CITY OF ALBUQUERQUE

November 17, 2020

**Re: Sandia Lab FCU
1100 Rio Grande Blvd NW
Traffic Circulation Layout
Engineer's 11-12-2020 (H13-D109)**

Based upon the information provided in your submittal received 11-11-2020, the above referenced plan cannot be approved for Building Permit until the following comments are addressed:

ENGINEER'S SEAL	SANDIA LAB FCU RIO GRANDE + 1-40 DETAILS	DRAWN BY RG
		DATE 10-8-2020
		DRAWING 2012100-SP
RONALD R. BOHANNAN P.E. #7868	 5571 MIDWAY PARK PL NE ALBUQUERQUE, NEW MEXICO 87109 (505) 858-3100 www.terrawestllc.com	SHEET # C3
		JOB # 2012100

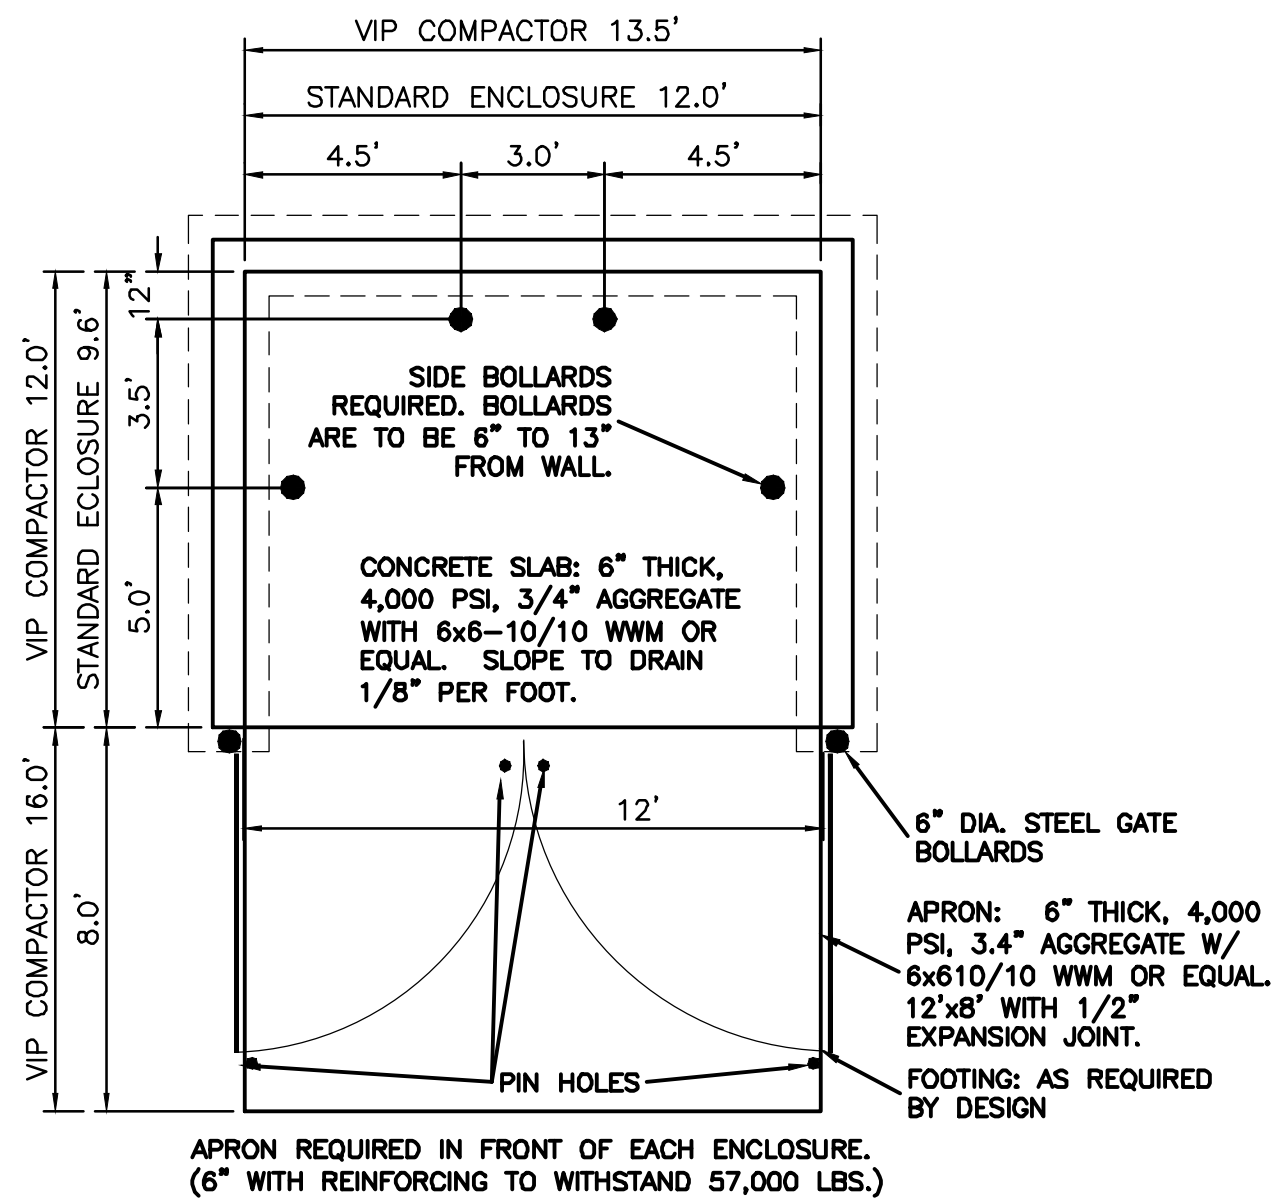
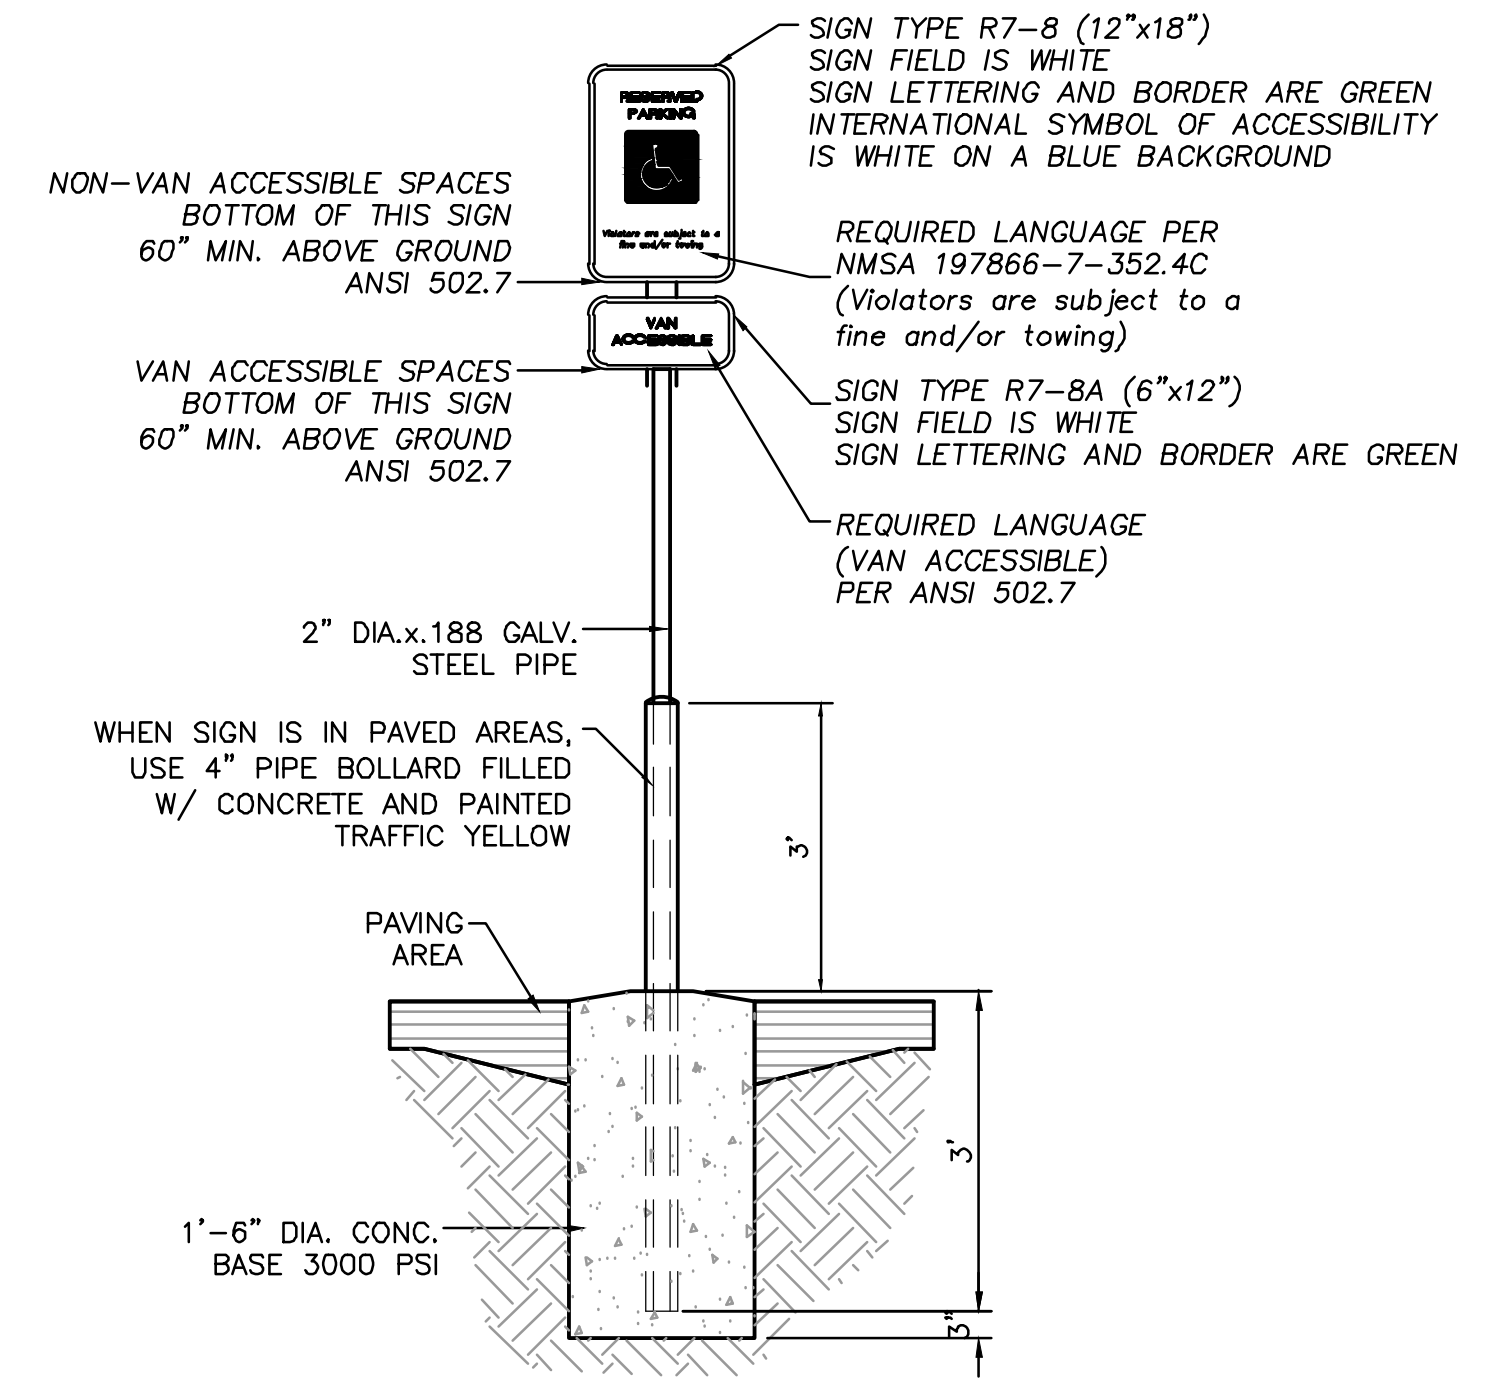
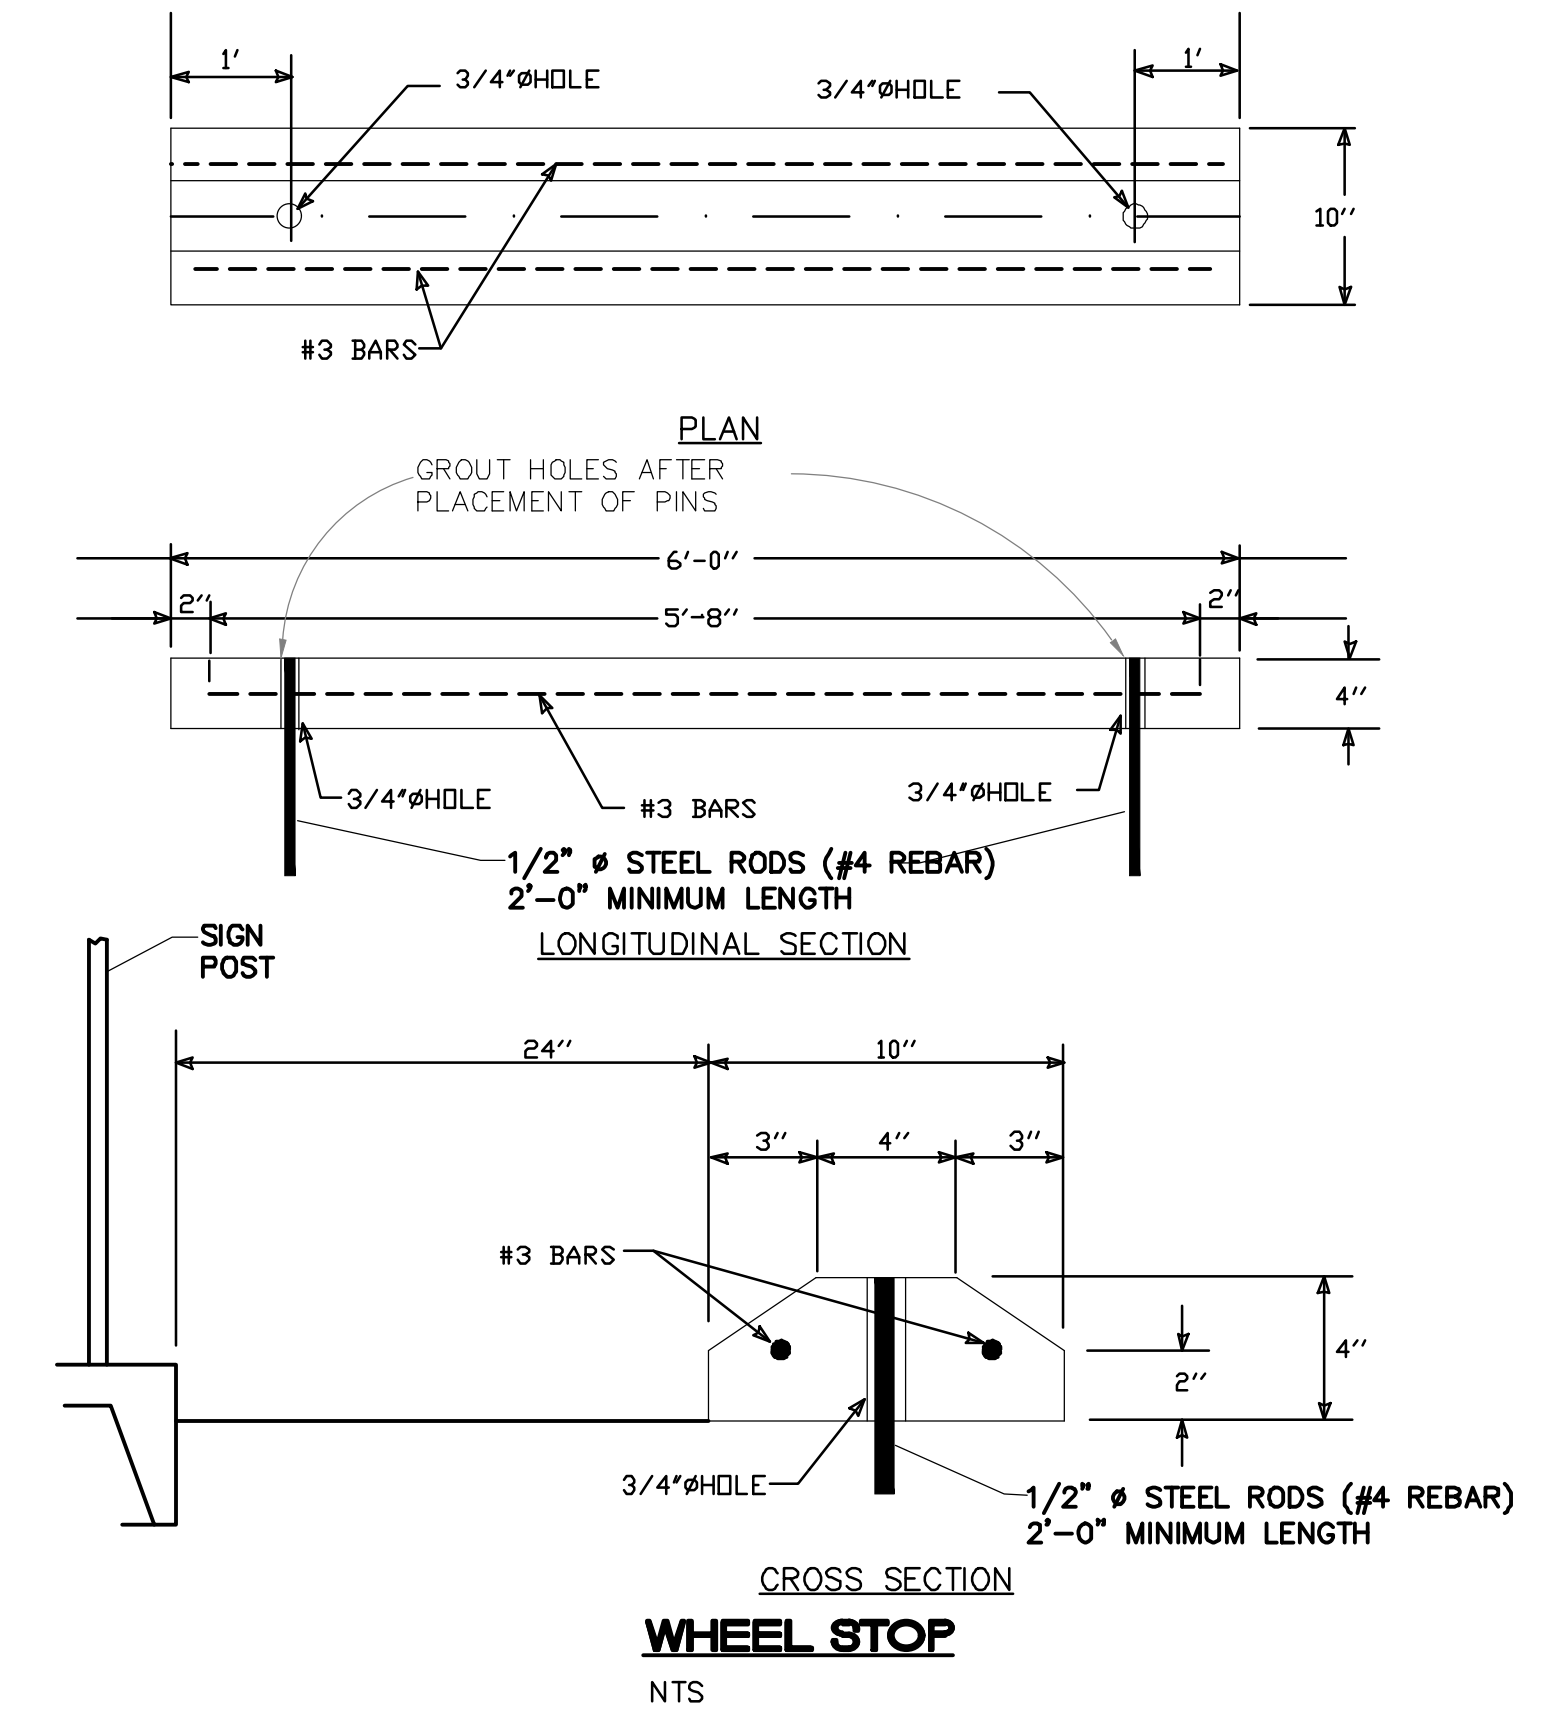
21. ADA parking aisle striping and pavement markings (No Parking): details of striping thickness, letter size and color will need to be provided.
22. Limits of proposed asphalt pavement within COA ROW will need to follow COA DPM and standards with Rvalue(min) 50. Show these limits.
